re: Geotechnical Design Summary Details
Proposed Building Addition
1250 and 1252 Wellington Street West – Ottawa, Ontario

file: PG5972-MEMO.02

Grading Plan Review

Site Servicing Plan Review

C301

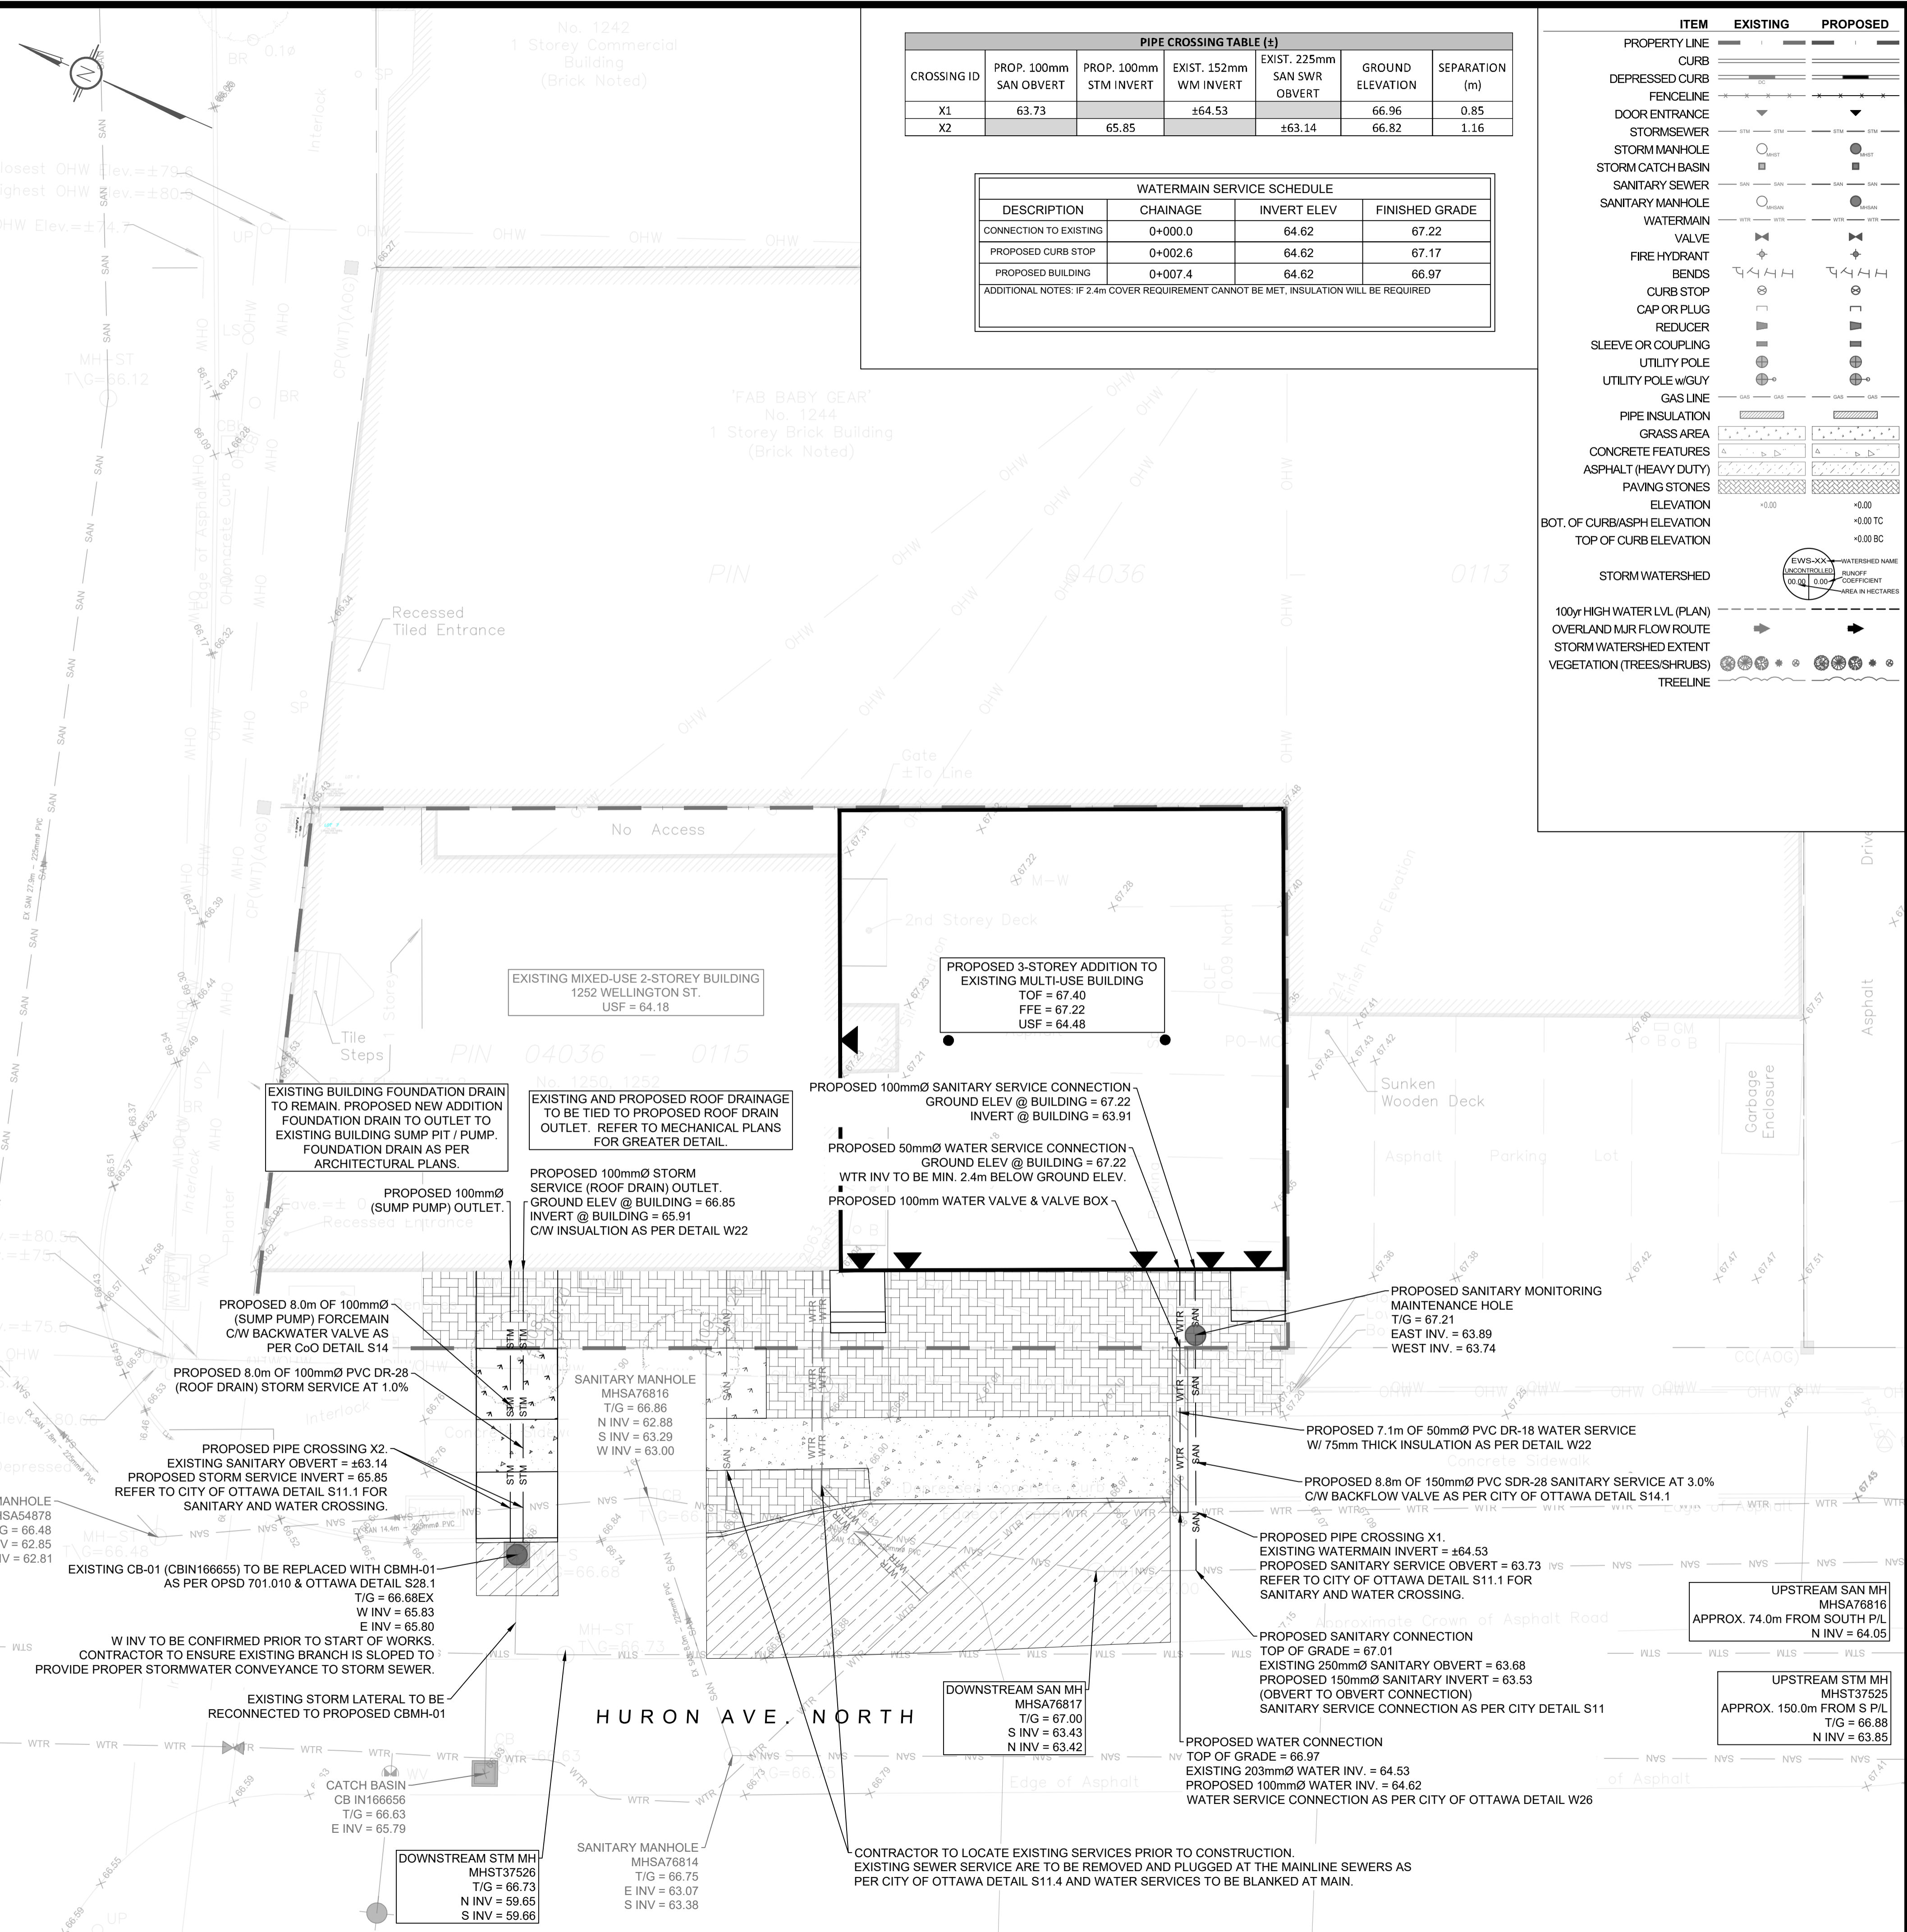
- ❑ Grading and Drainage Plan – Proposed Addition to Mixed Use Building, 1252 Wellington St., Ottawa, ON. – Project No. 210883 – Drawing No. C301 – Review 1, dated March 16, 2022.

Based on our review of the aforementioned grading plan, the proposed grades are within the permissible grade raise restriction provided. Therefore, the proposed grading plan is considered acceptable from a geotechnical perspective and no lightweight fill or other considerations to accommodate the proposed grades are required at this time.

**C401**

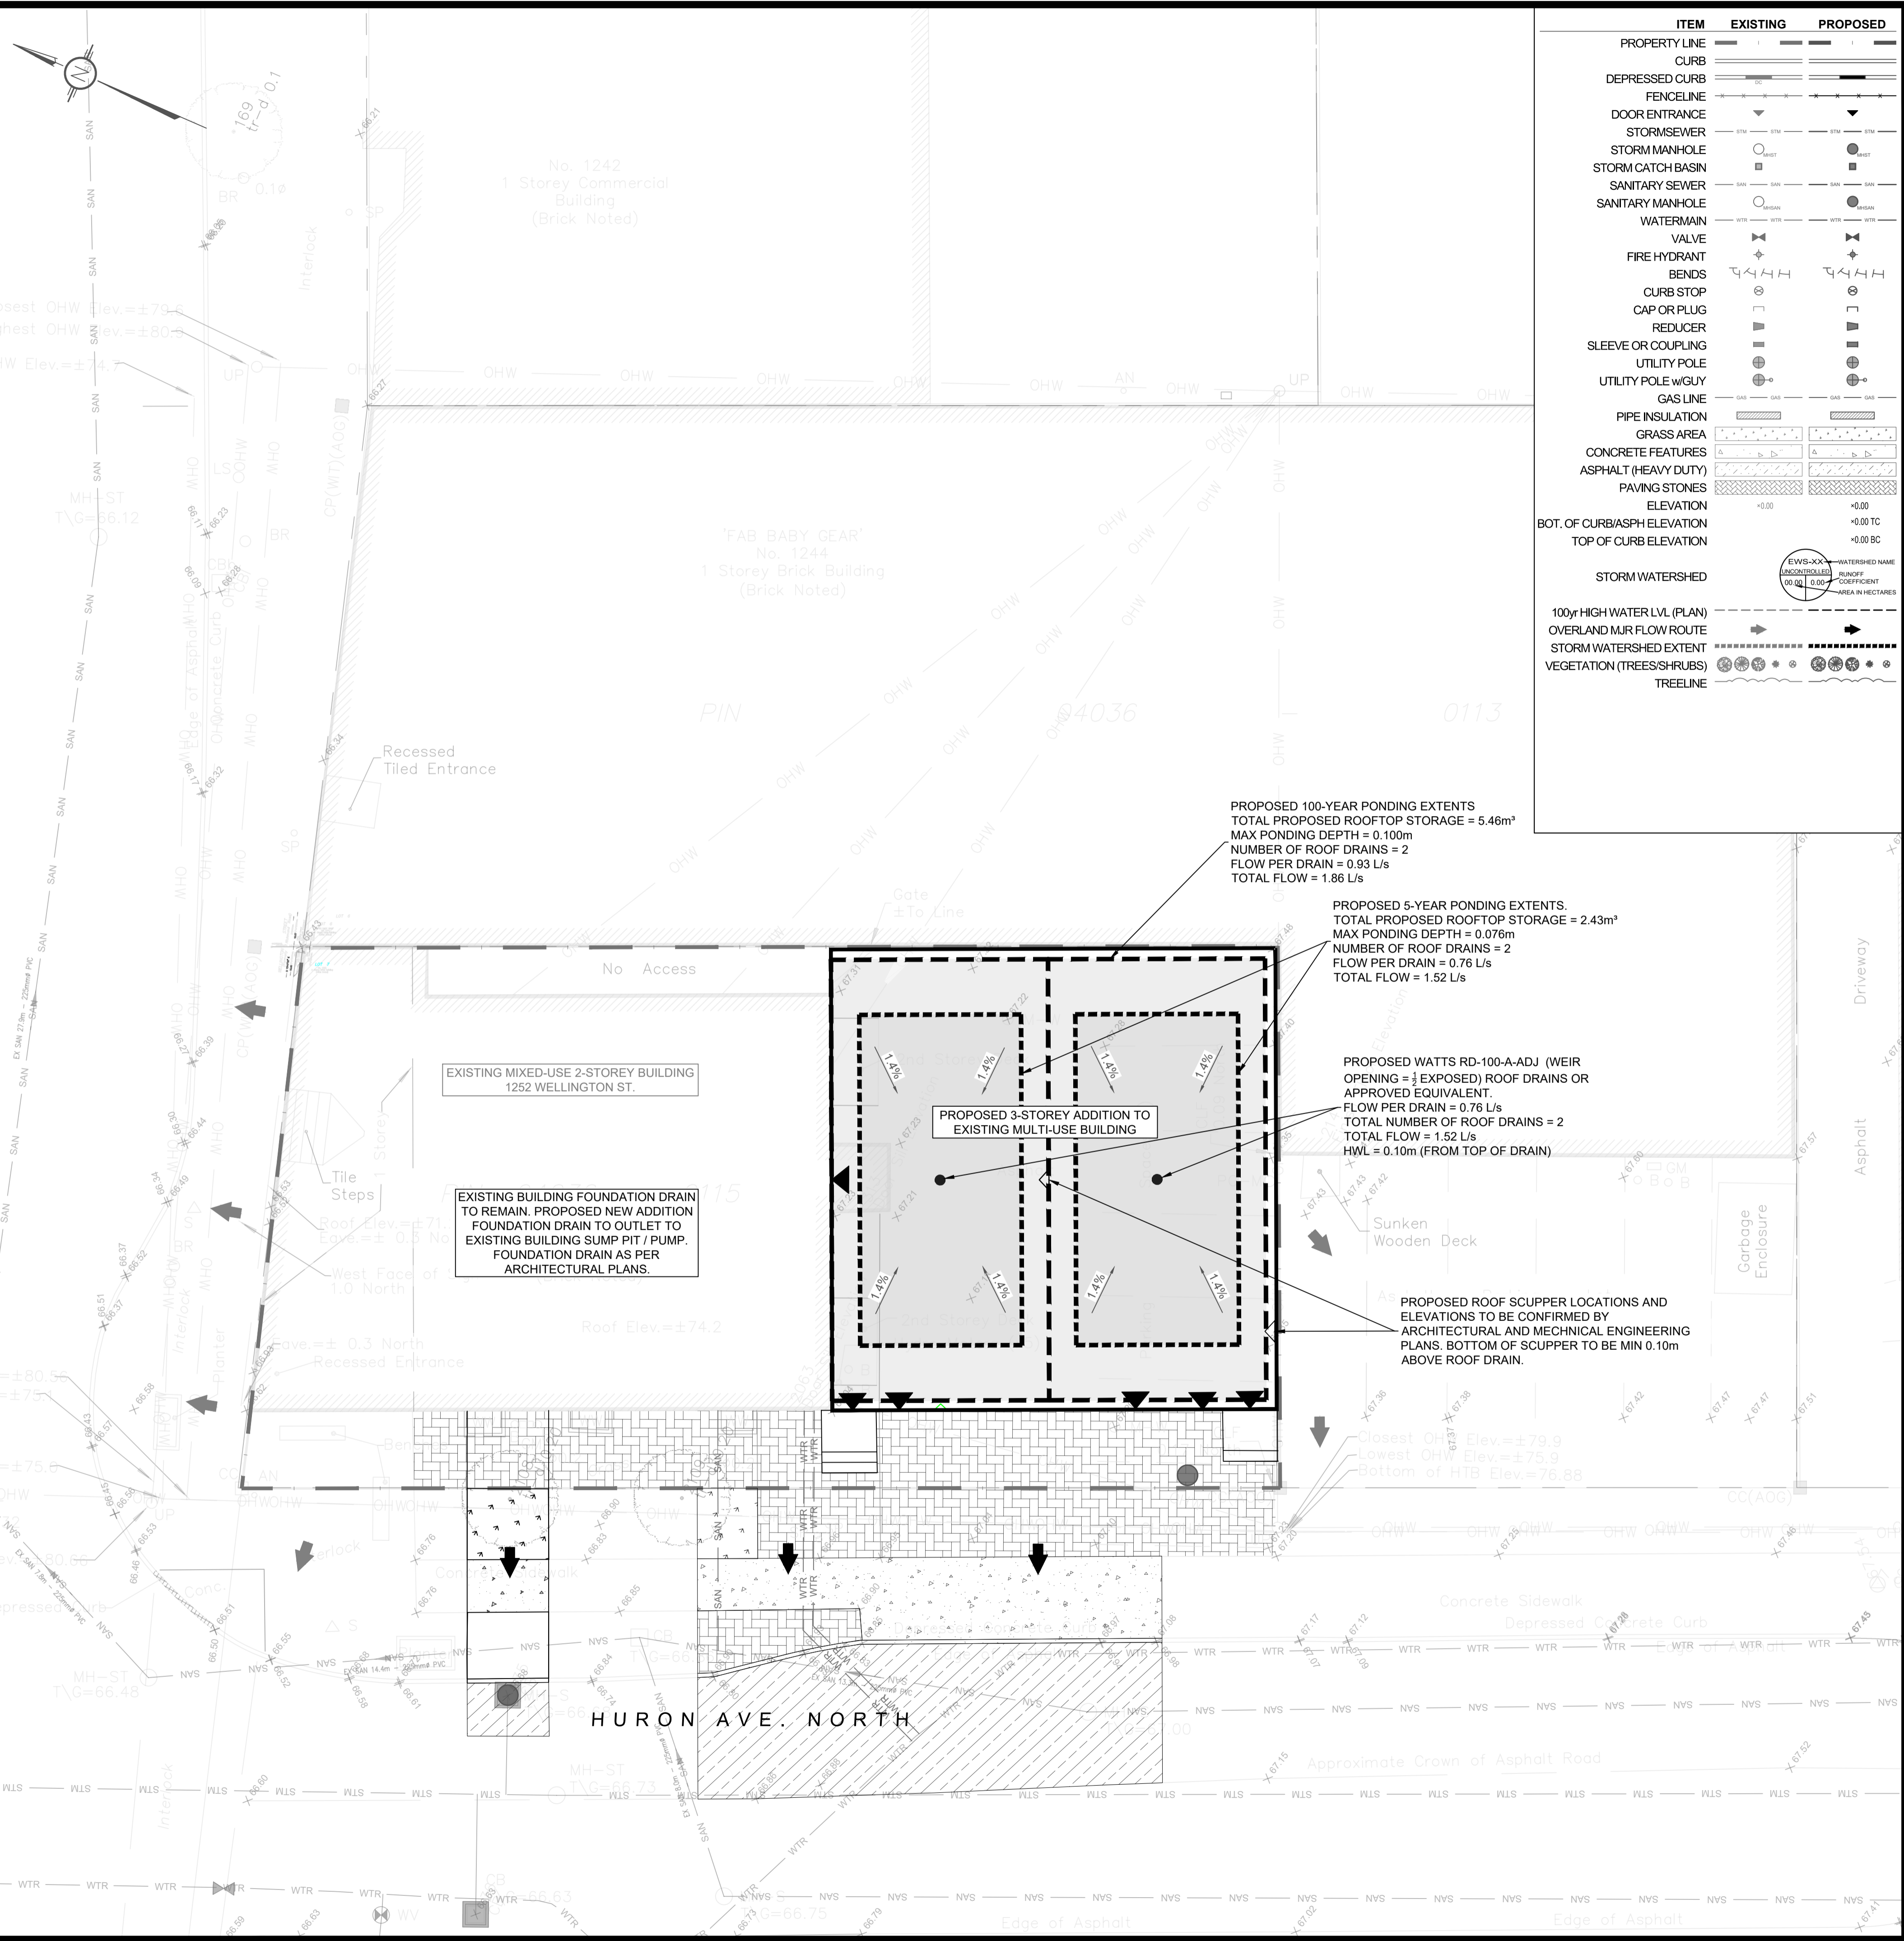
- Servicing Plan – Proposed Addition to Mixed Use Building, 1252 Wellington St., Ottawa, On. – Project No. 2108 33 – Drawing No. C401 – Revision 1, dated March 16, 2022.

From a geotechnical perspective, the relevant recommendations including adequate frost protection of services, foundation, pipe bedding and backfill provided by Paterson in the aforementioned geotechnical investigation report have been incorporated satisfactorily into the above noted plans.
